24th October 2021

Ref: EP/132/21

**Application for Non-Material Amendment Following Conditional Planning Permission 27a
Sea Lane, East Preston, BN16 1NH (EP/2/21/HH)**

Rear Elevation (east)

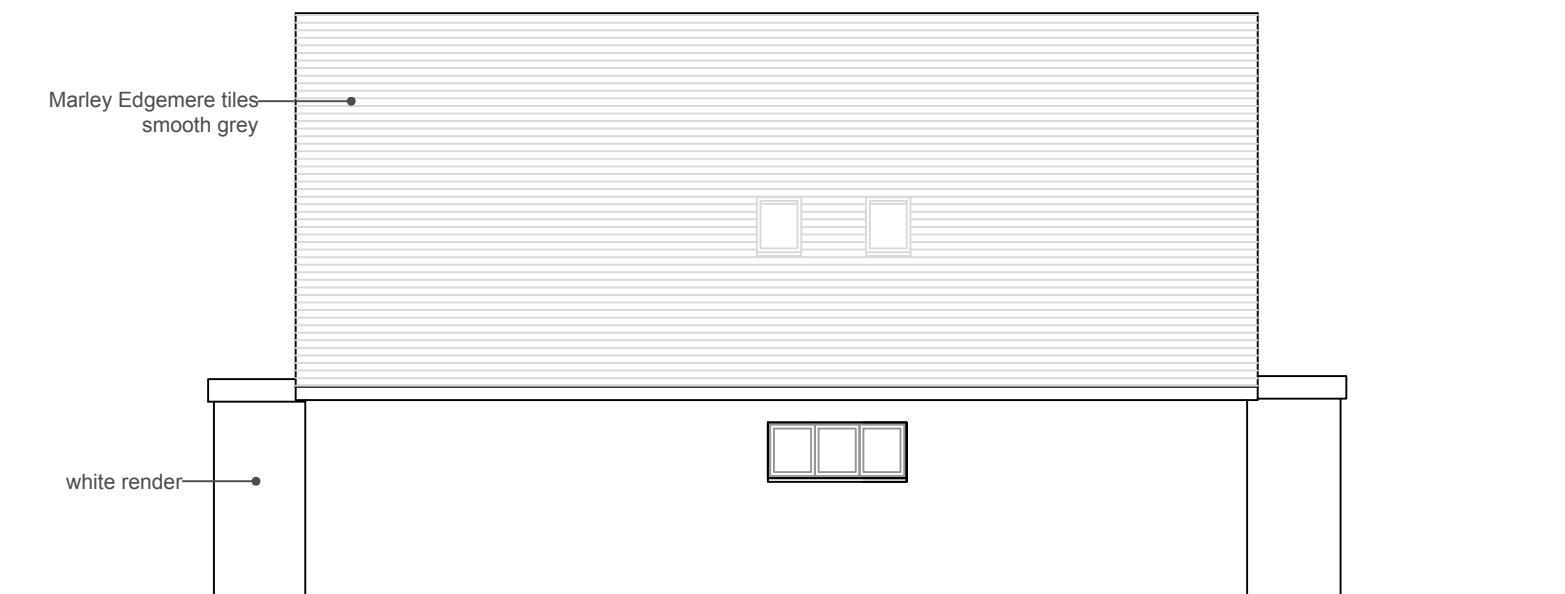
The non-material amendment plans dated 15th October a Juliet balcony to the rear, but the two full height doors, as originally sought, have reappeared on the plans.

The Juliet balcony is very close to our boundary and having two full height doors will provide more opportunity for two people to push the doors right back and sit elevated above our garden. We will be able to look up into the double doors. They will be able to look down through two doors instead of one and there will be a wider glass balustrade. There is no other ventilation to this room on the plans so the doors will need to be opened more often than would have been the case if there had been half height windows, thus providing more opportunity for overlooking.

The increased overlooking will affect our amenity and enjoyment of our garden. We are West facing and our house shadows much of our garden in the afternoon, so we use the back part of our garden a lot. It will also increase the overlooking of our neighbours in Oakley Gardens who have small gardens directly backing onto 27a. The double doors can be clearly seen by the public from the Twitten adjacent to our property.

We understand that there are cost implications in asking for a return to plan. However, at the very least we feel that opaque or frosted glass should be used for the balustrade to the rear Juliet balcony. This would help us and our neighbours with overlooking. We also would like to know if it is possible that a note be made that no further non-material amendments can be made to enable a full balcony to be granted.
